File No: COM-19-031

Cimarron Service Center
2283 Waynoka Rd.
 El Paso County, Colorado

DRAWING NO.
SP1
 SITE PLAN
 Sheet 1 of 1

COM drawing-redline.pdf Markup Summary

2 SITE PLAN

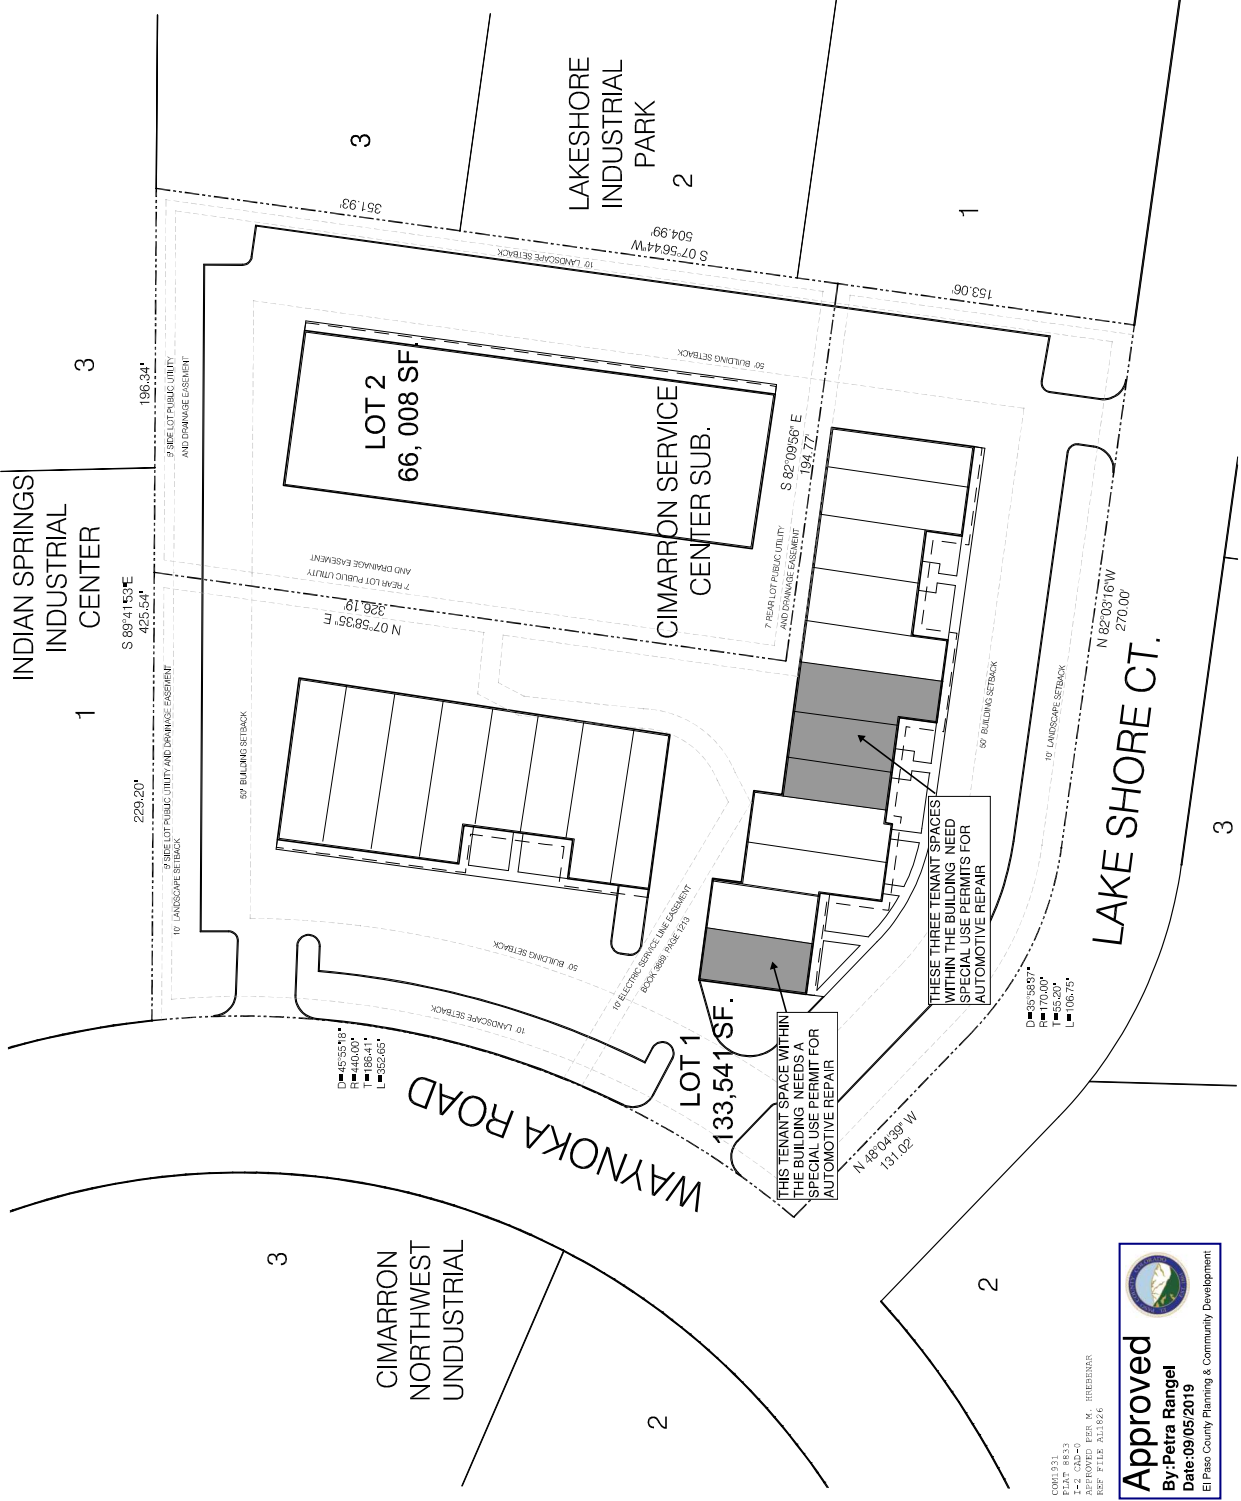
Include this note:
 The parties responsible for this plan have familiarized themselves with all current accessibility criteria and specifications and the proposed plan reflects all site elements required by the applicable ADA design standards and guidelines as published by the United States Department of Justice. Approval of this plan by El Paso County does not assure compliance with the ADA or any regulations or guidelines enacted or promulgated under or with respect to such laws.

Show a route from the ADA parking spaces to the entrances of the structures.
